# KIRKLEES METROPOLITAN COUNCIL INVESTMENT & REGENERATION SERVICE

### DELEGATED DECISION TO DETERMINE PLANNING APPLICATIONS

Reference No:	<b>2025/62/90487/E</b>
Site Address:	47, Huddersfield Road, Mirfield, WF14 8AE
Description:	Change of use and alterations to convert from vacant bank (Class E) to hot food takeaway (sui generis) with installation of extract and ventilation equipment and external alterations to the front and rear elevations
Recommending Officer:	Nicole Helliwell

#### **DECISION - Refuse**

title  
**Proposed**  
Ground Floor Layout

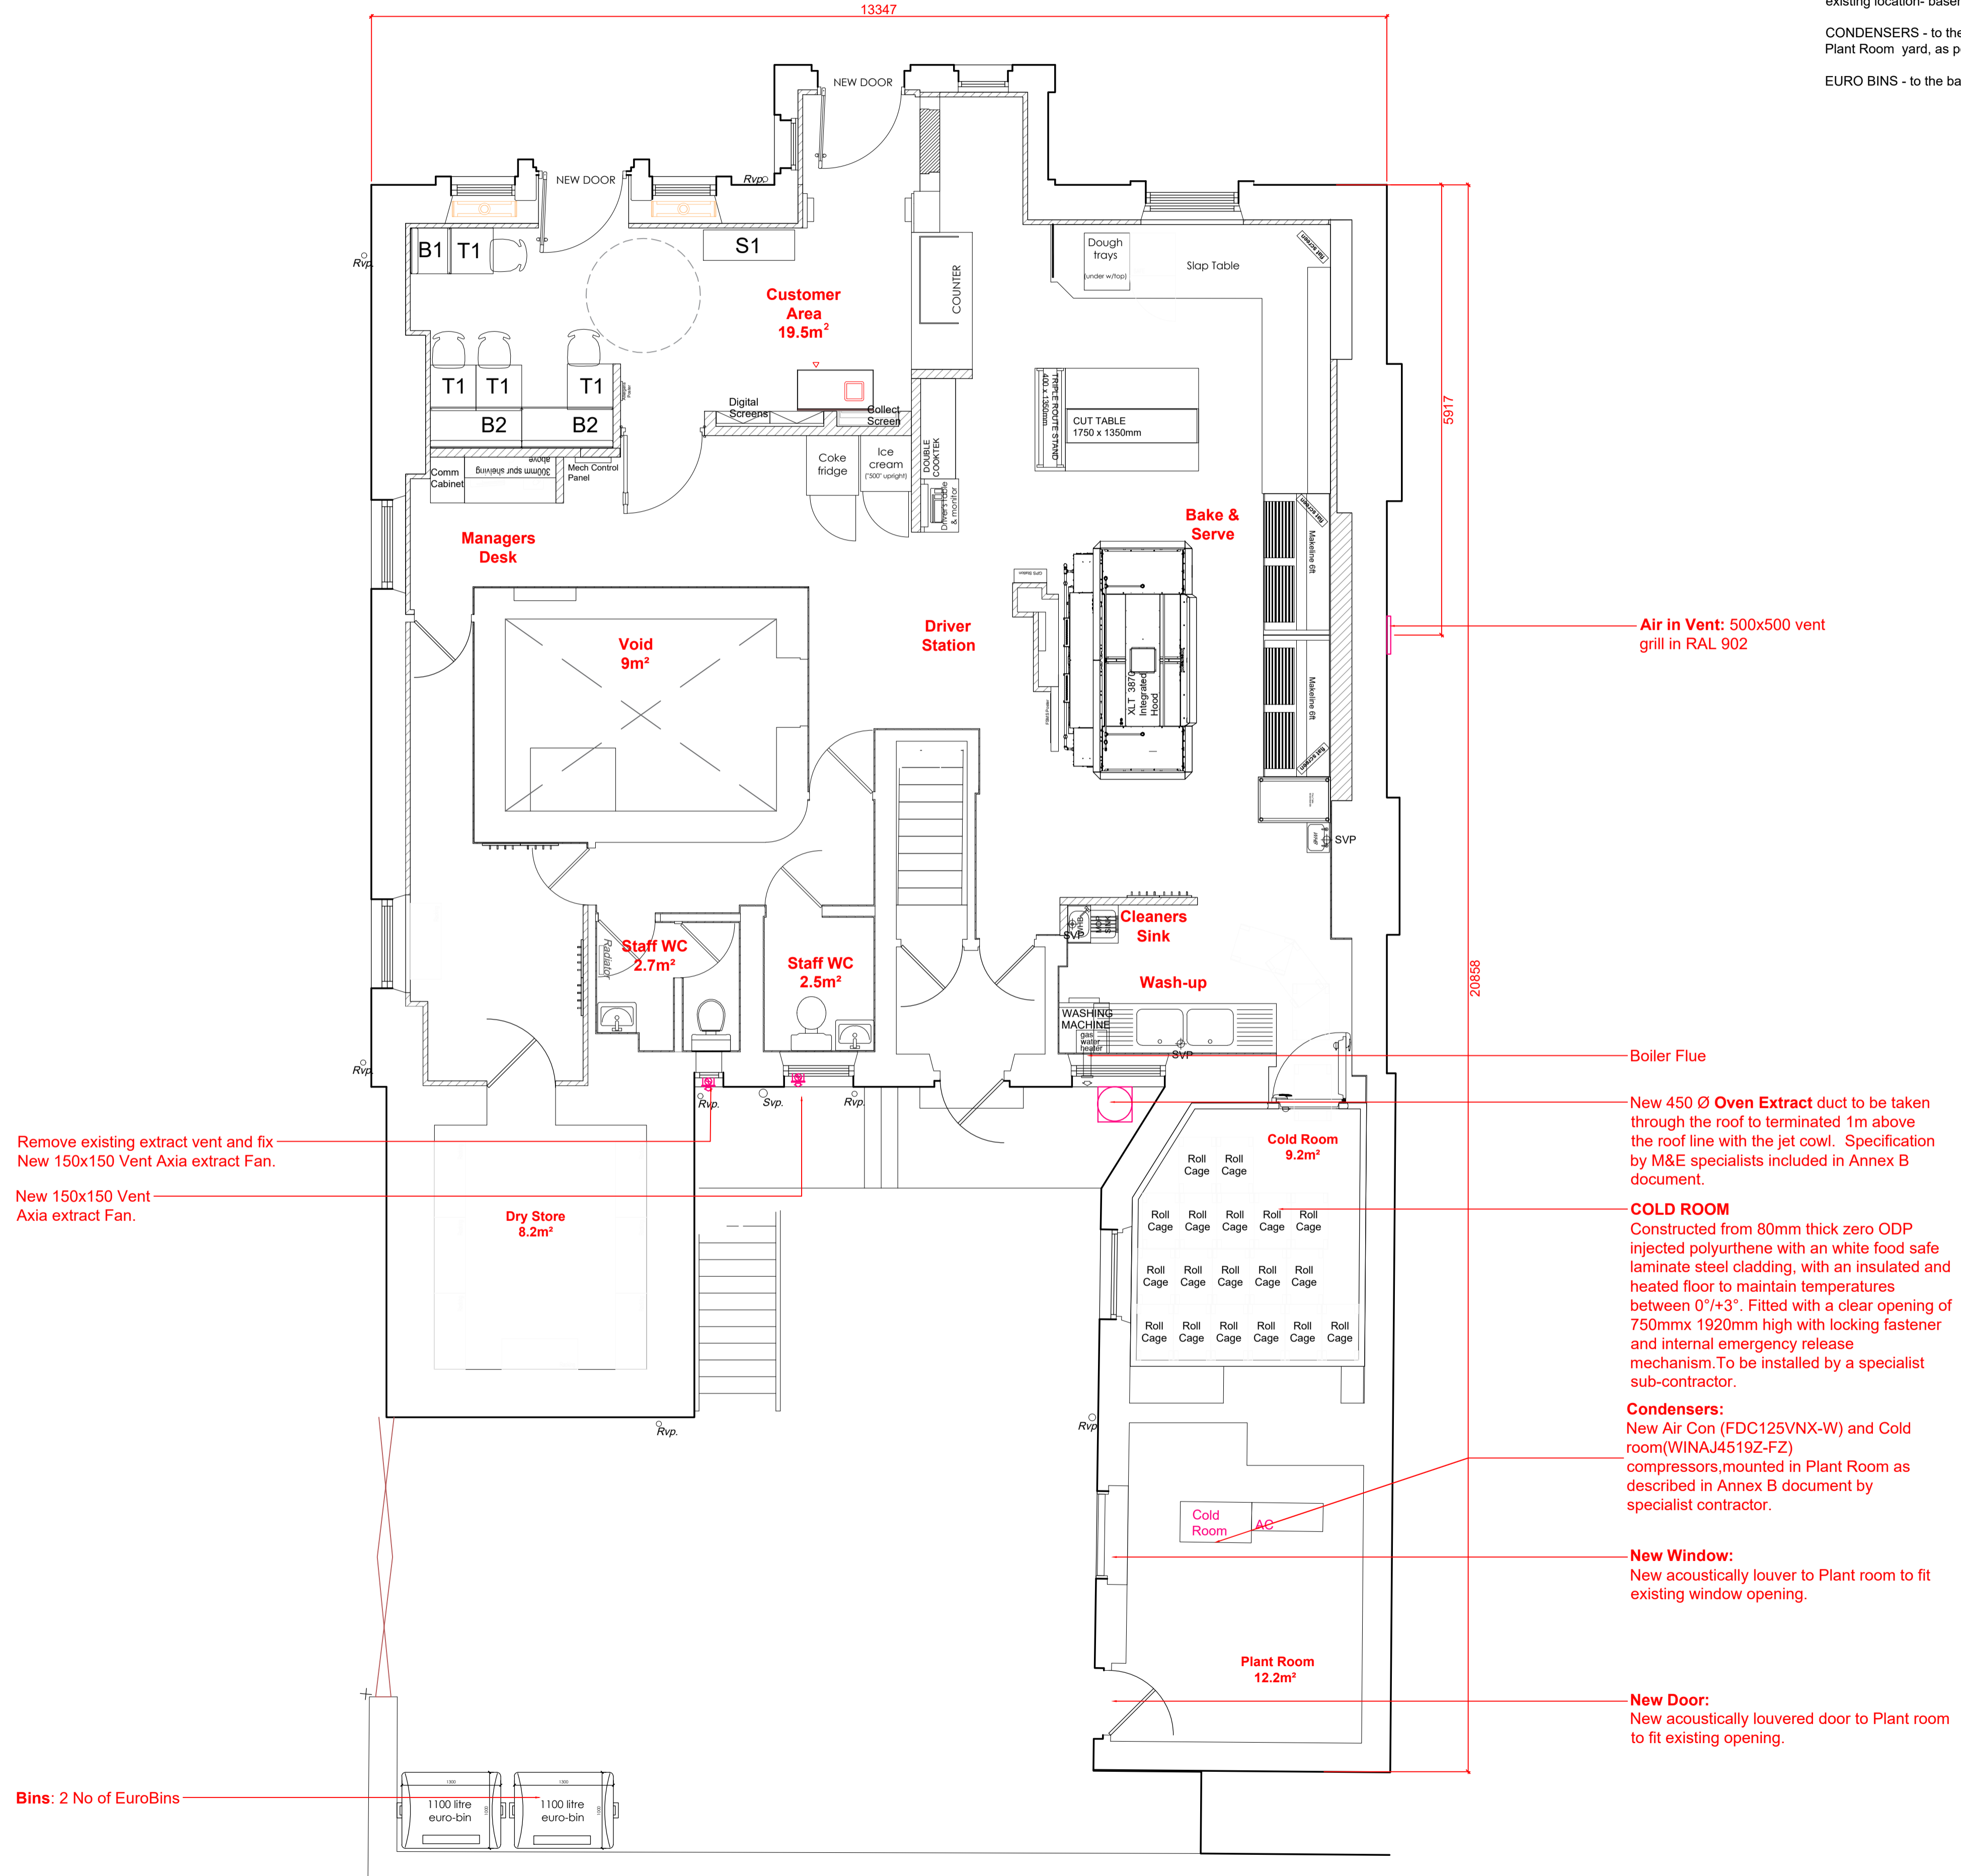
2. The proposal has not included an evidence based swept path analysis, and the impact upon access to bin storage and accessibility for waste collection wagons which could give rise to highways safety, adversely affecting road users and pedestrians. This is contrary to policies LP21 & LP22 of the Kirklees Local Plan.

4. The development will give rise to an adverse effect upon residential amenity in regard to noise pollution in the form of the noise impact of the oven extract duct located on the rear elevation of the building contrary to Policies LP24 and LP52 of the Kirklees Local Plan and Chapters 12 and 15 of the National Planning Policy Framework.
